**SAN IGNACIO SUBDIVISION
DRAINAGE AND GRADING PLAN**

**1500 Edith Blvd., N.E.
in Albuquerque, New Mexico
May, 1996**

J-14/D

**RE: SAN IGNACIO SUBDIVISION (J14-D115) DRAINAGE REPORT SUBMITTAL FOR
PRELIMINARY PLAT APPROVAL. ENGINEER'S STAMP DATED MAY 22, 1996**

Drawing file: FINAL / G&D Plan 05-22-96.pdf

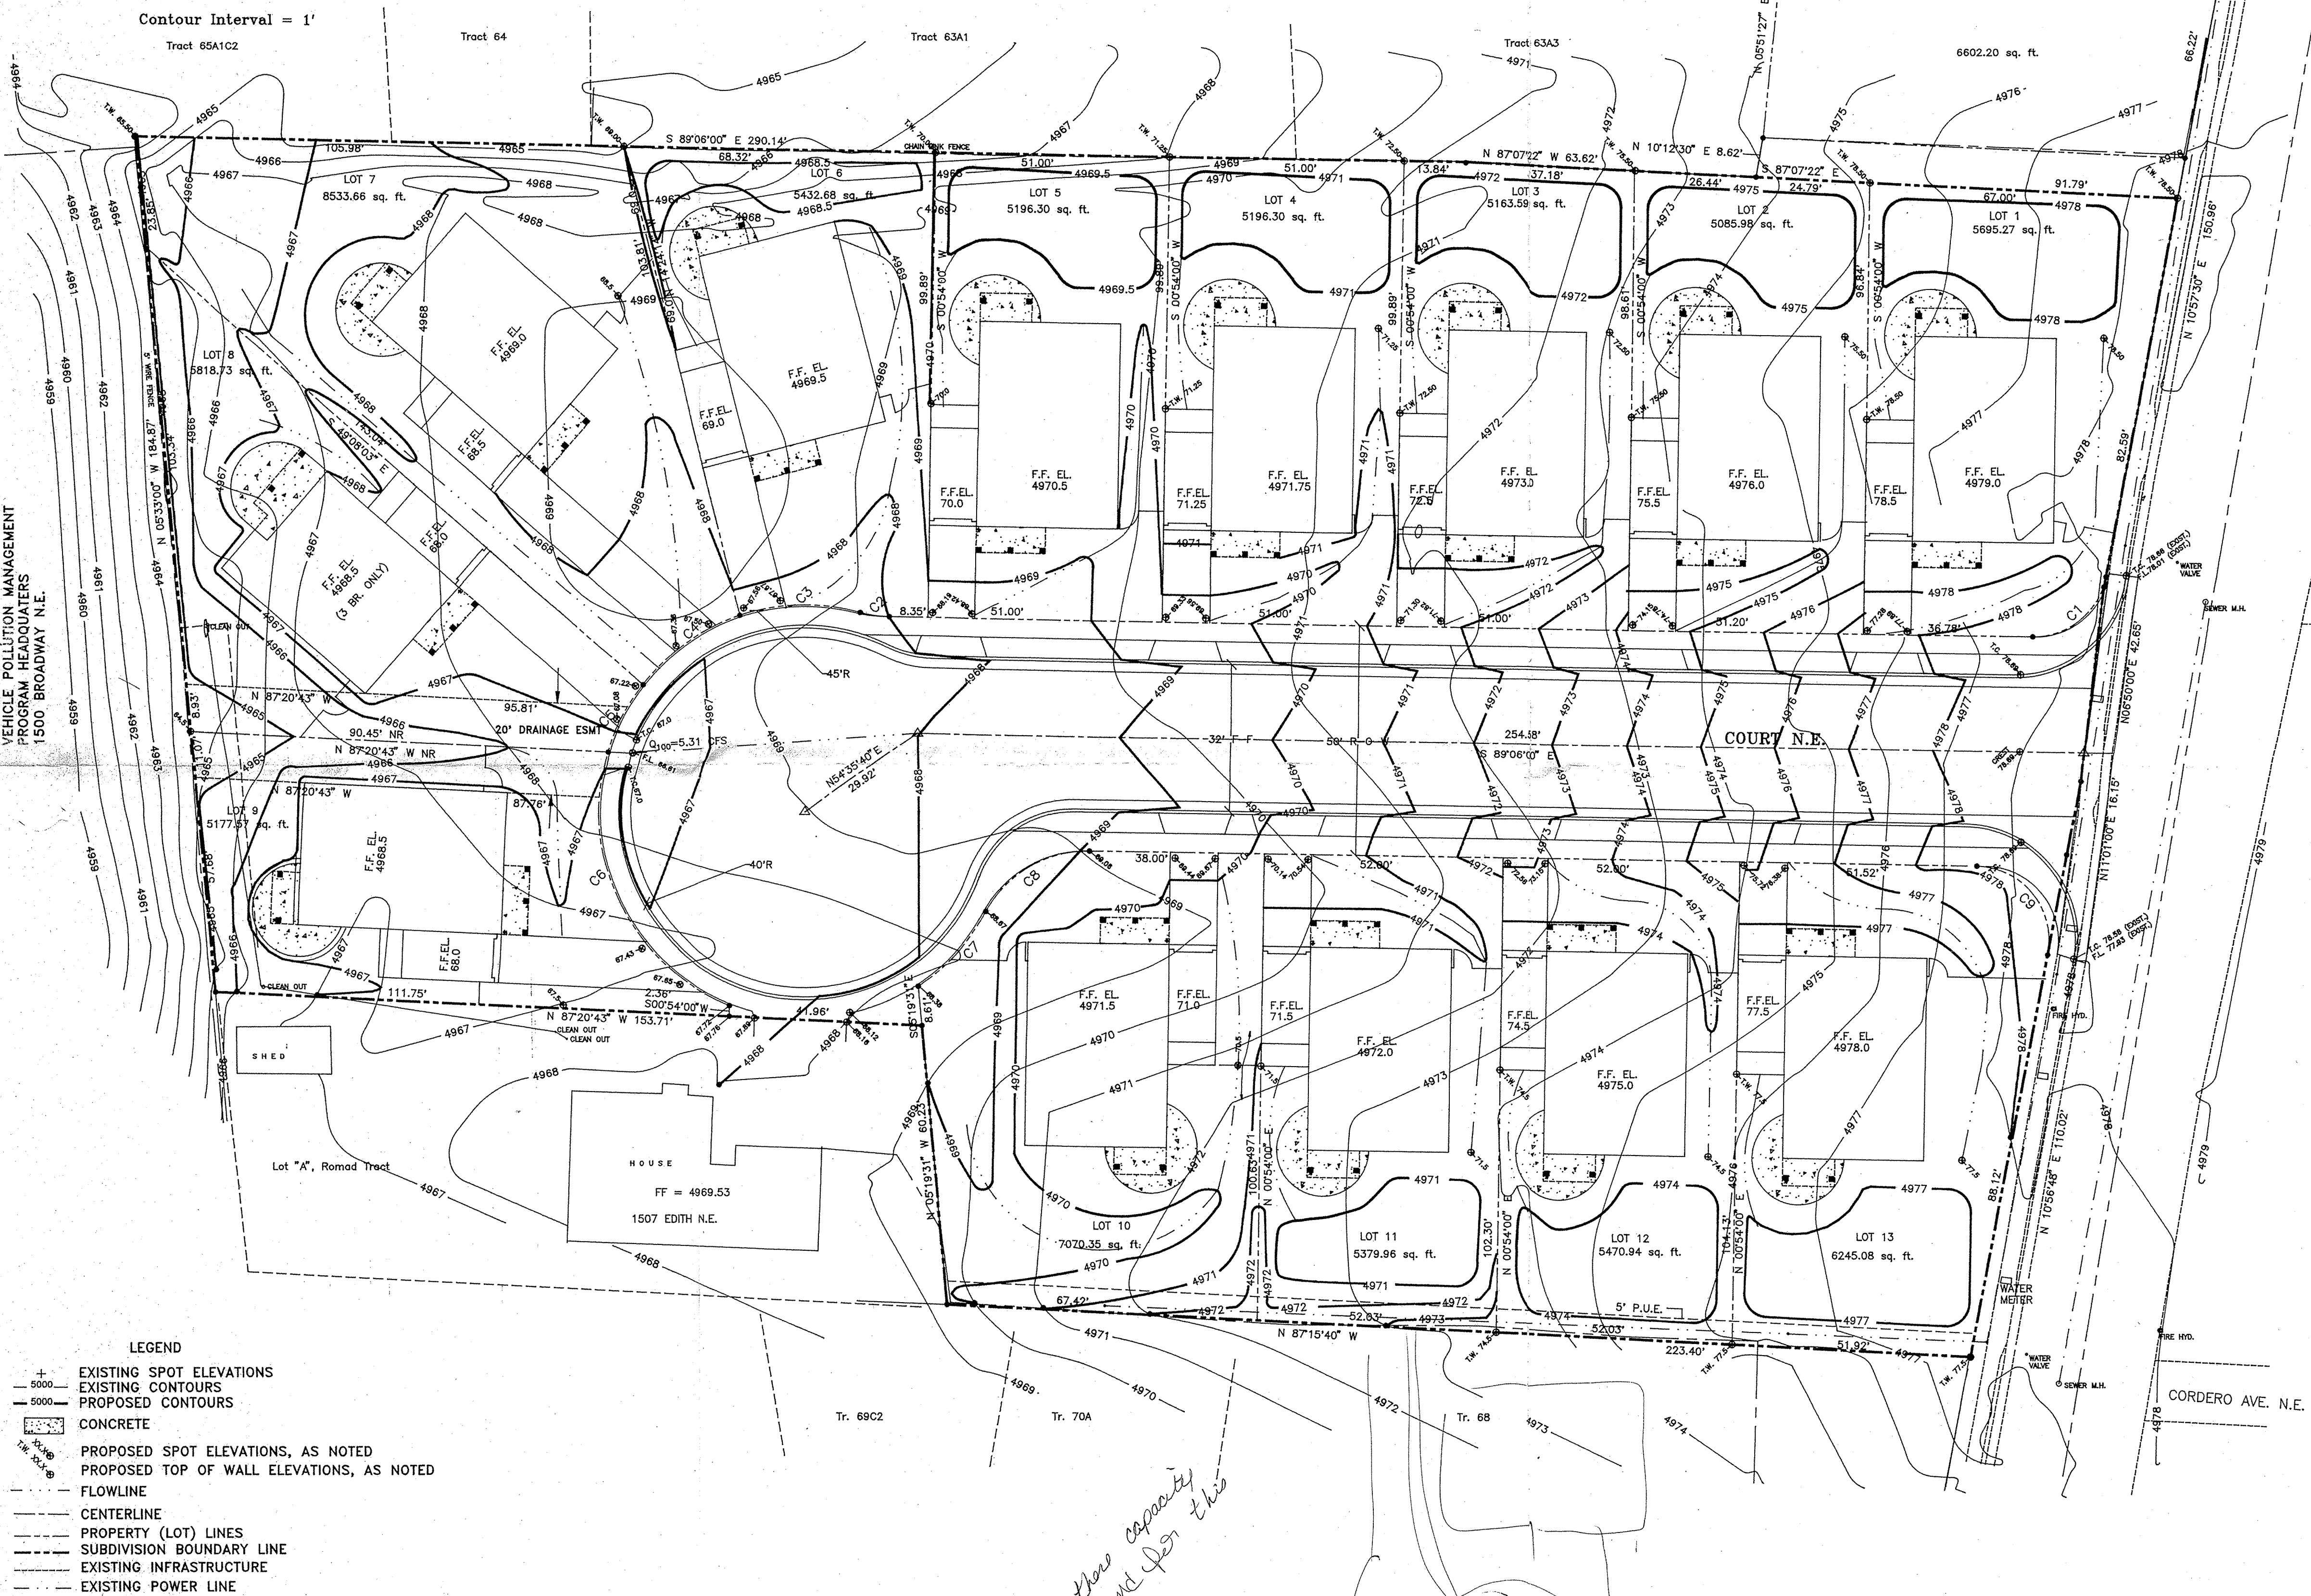
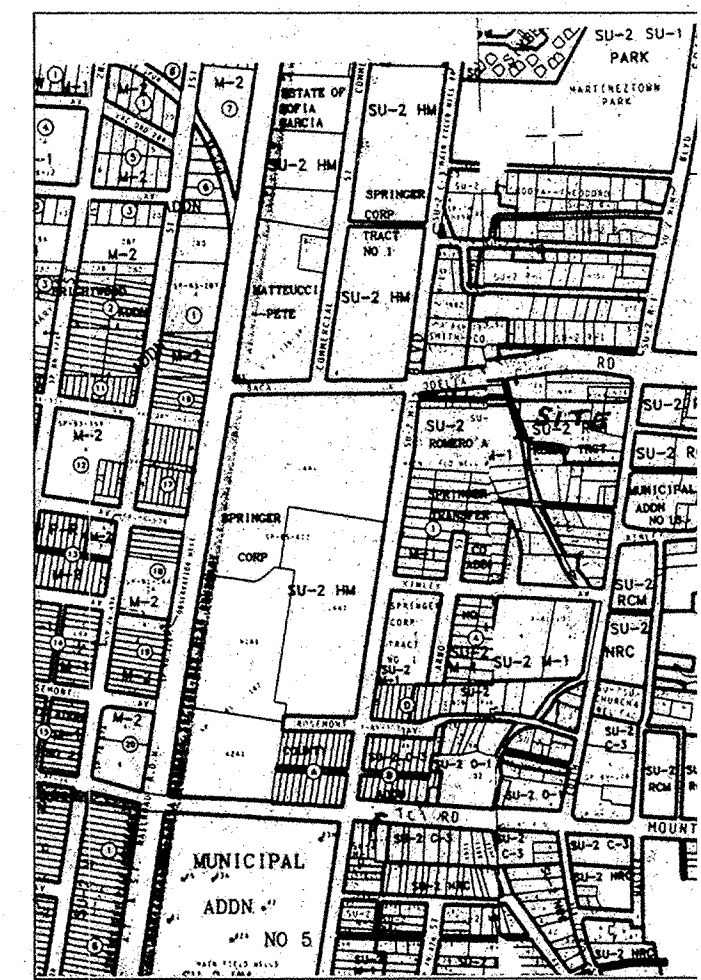
Based on the information provided on your May 23, 1996 submittal, City Hydrology has the following comments:

1. Easements will be required for flow draining through adjacent property to the off site detention pond.
2. Is there capacity in the off site detention pond for the flow generated by the proposed development? Keep in mind that historical conditions do not necessarily represent actual downstream capacity.
3. If you want to use an 18" pipe and inlet, please indicate this on the plan sheet and show details. You will need permission from the adjacent property owner to install a discharge line.
4. You cannot take credit for backyard retention ponds when determining the amount of flow discharged from this site. Your drainage controls must be designed as if no water were being retained.
5. I was unable to find the benchmark on the plan sheet.
